Please ask for: Ms Iqraa Malik
Email: iqraa.malik@terraquest.co.uk
Telephone: 01212341390
Our Ref: R/106/21/HH
Your Ref:
Date: 11th May 2021

Application for Planning Permission for Works or Extension to a Dwelling

Development: Erection of single storey rear extension and hip to gable loft conversion with 1 x side dormer
Location: 26 Tennyson Avenue Rustington BN16 2PH

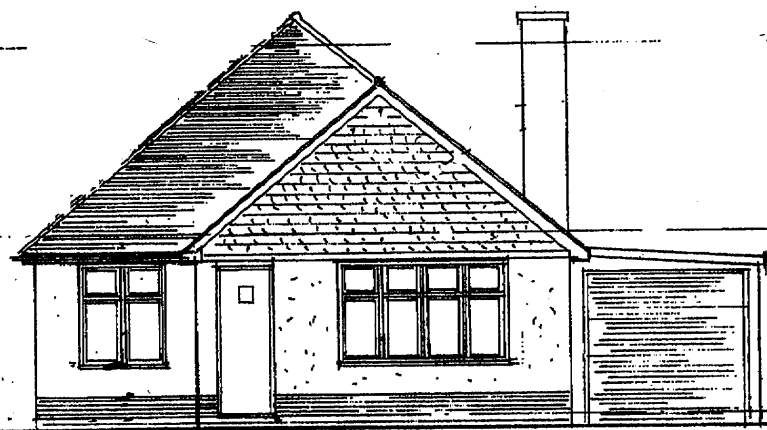
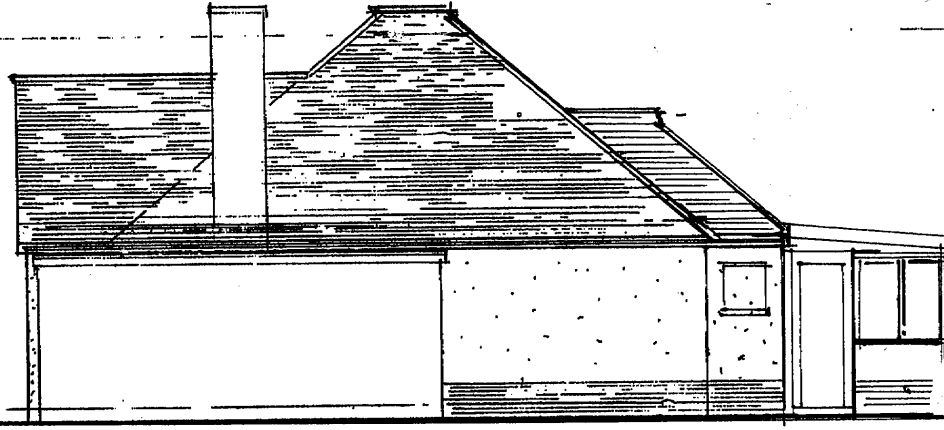
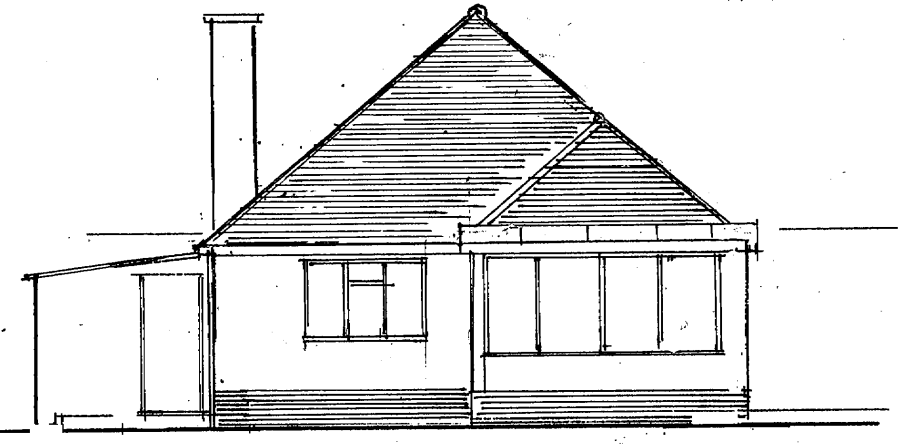
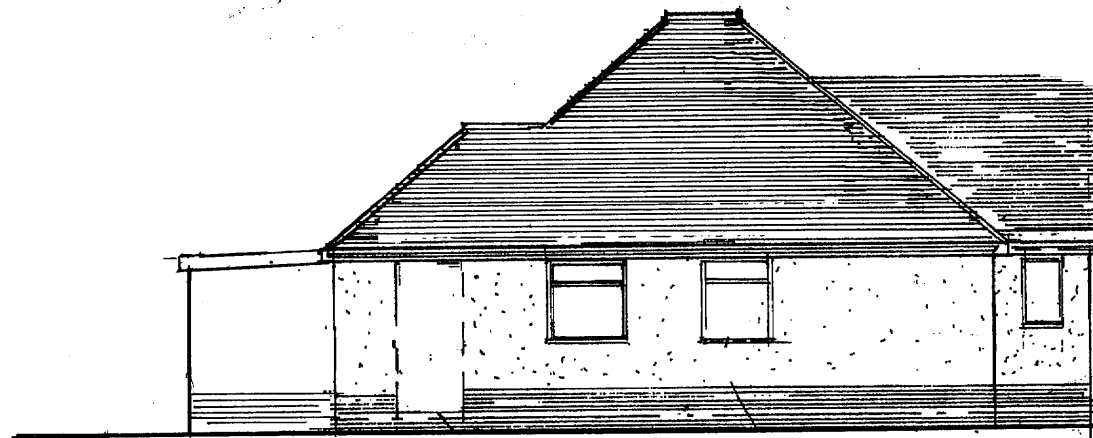
The door on the existing side elevation is shown as a window on the existing floor plan. Please review and amend accordingly.

26, Tennyson Avenue

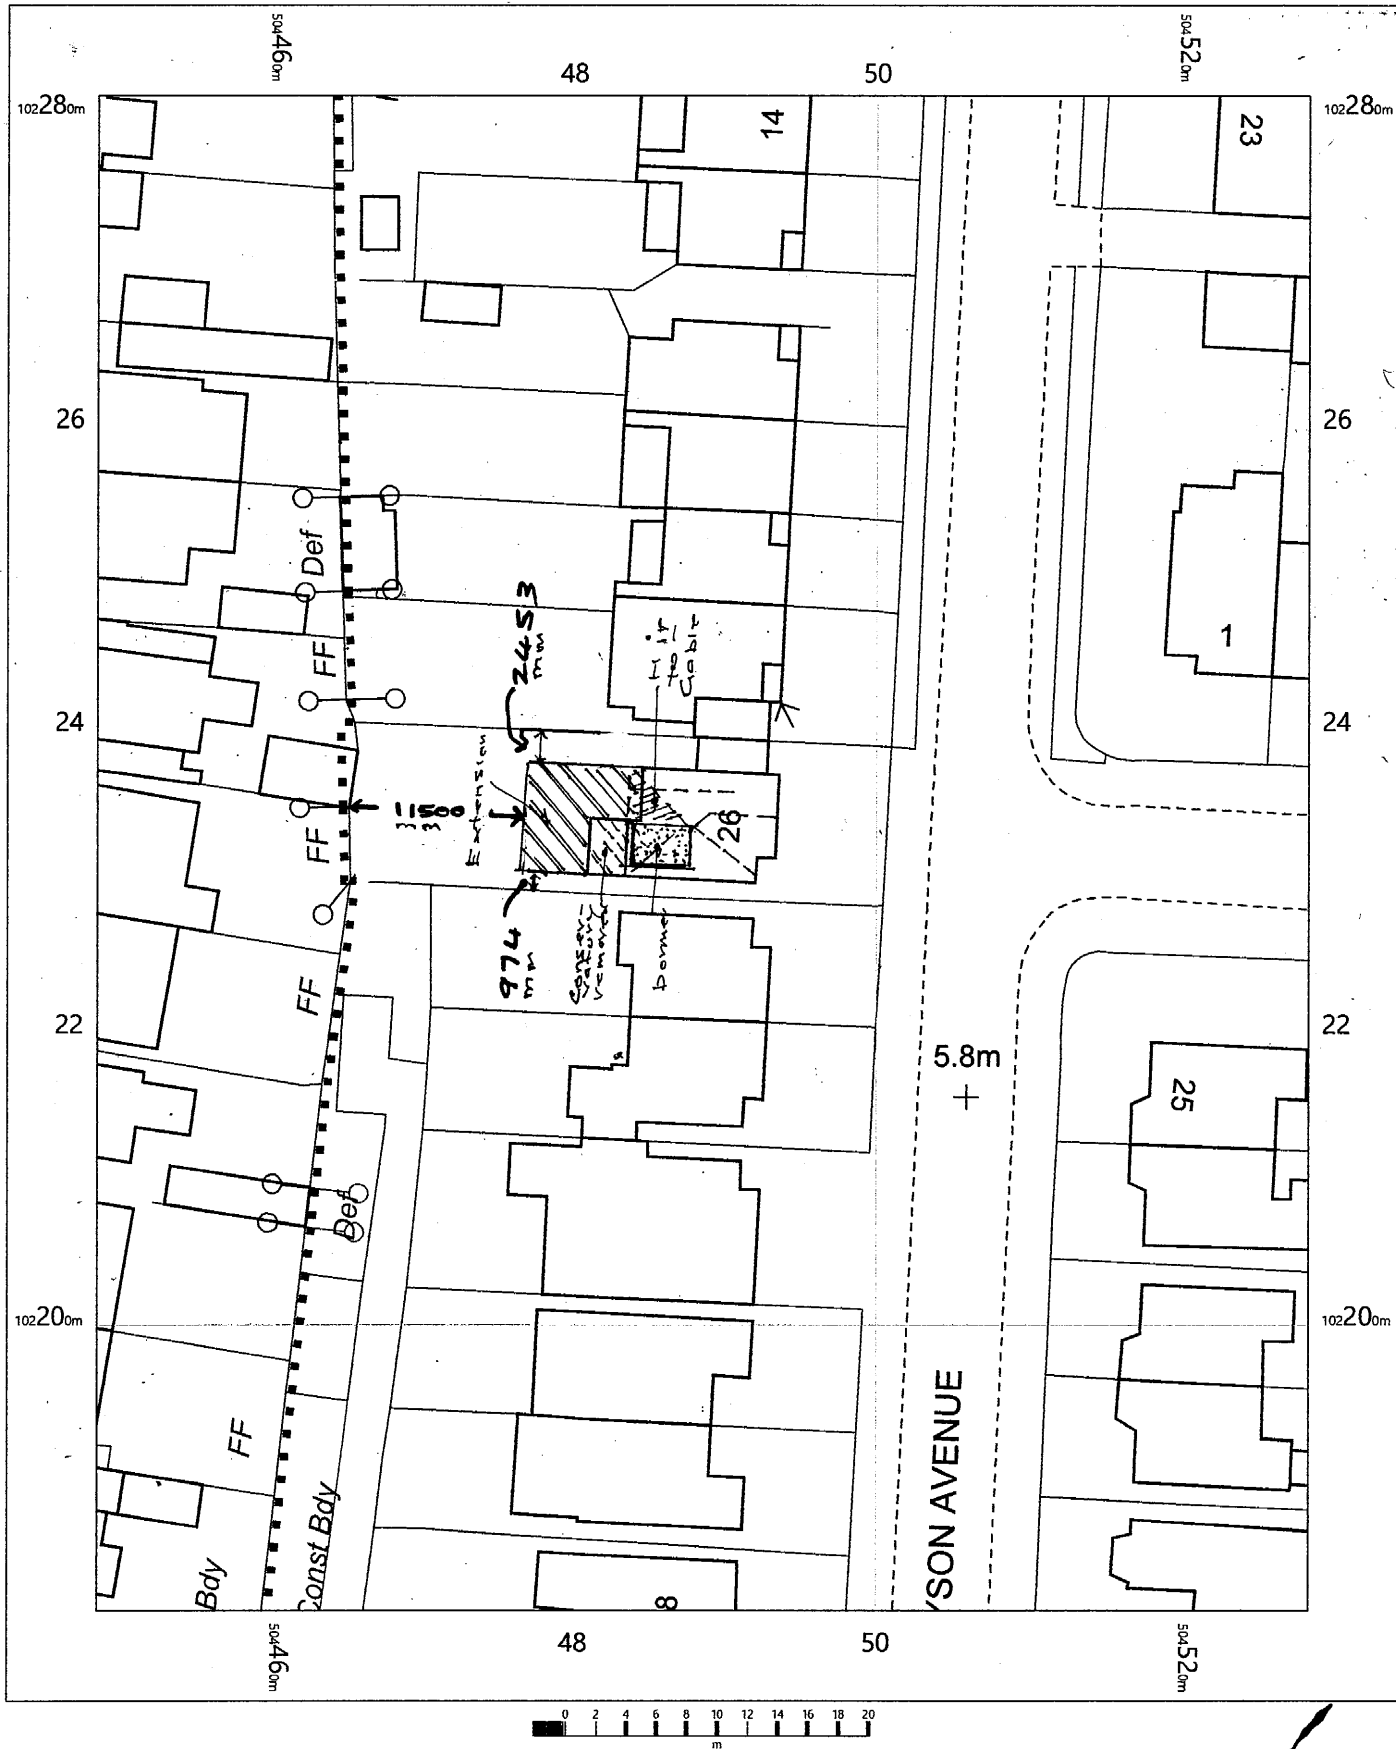
Block Plan

You are required to have dimensions from the proposed extension(s) to all site boundaries. Please amend

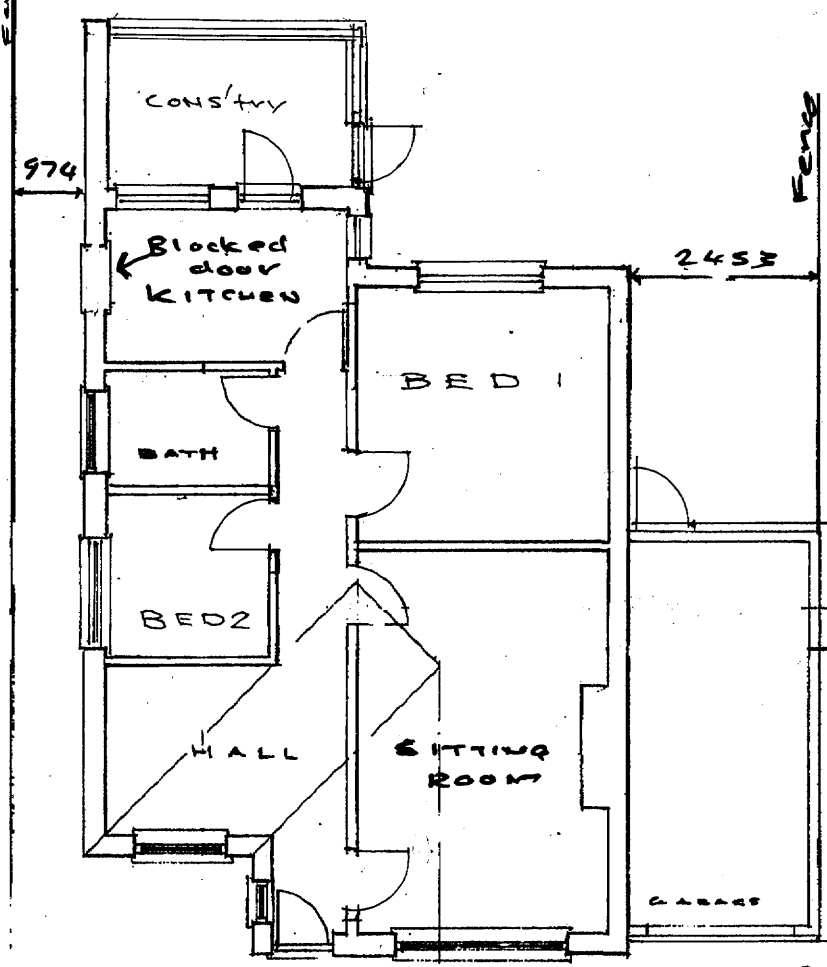
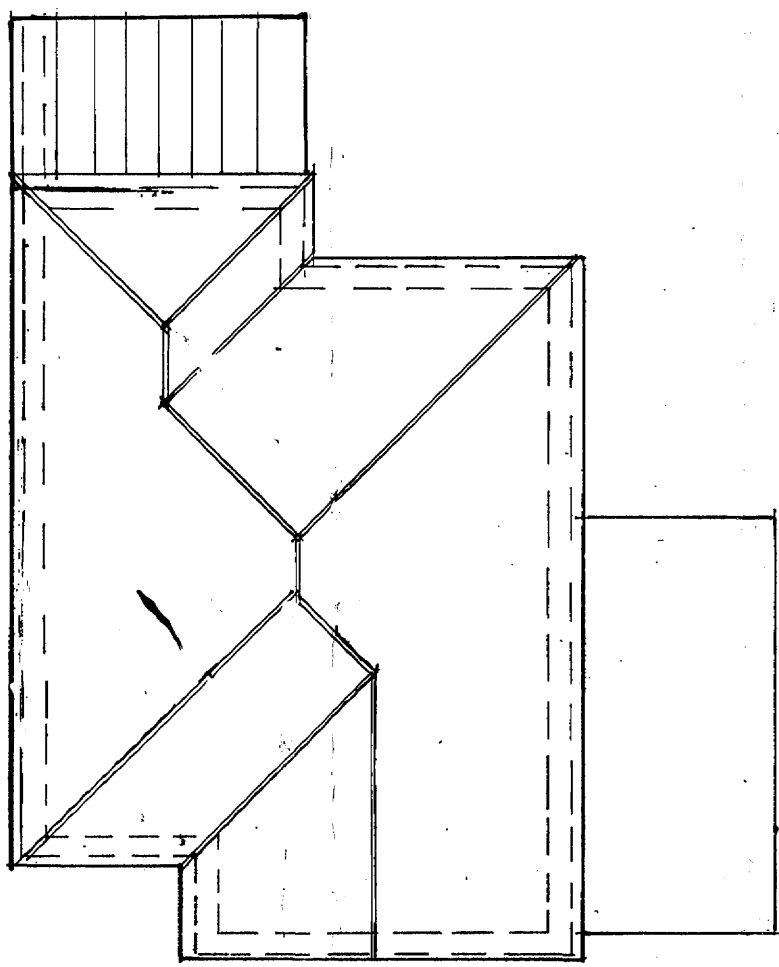
Plans
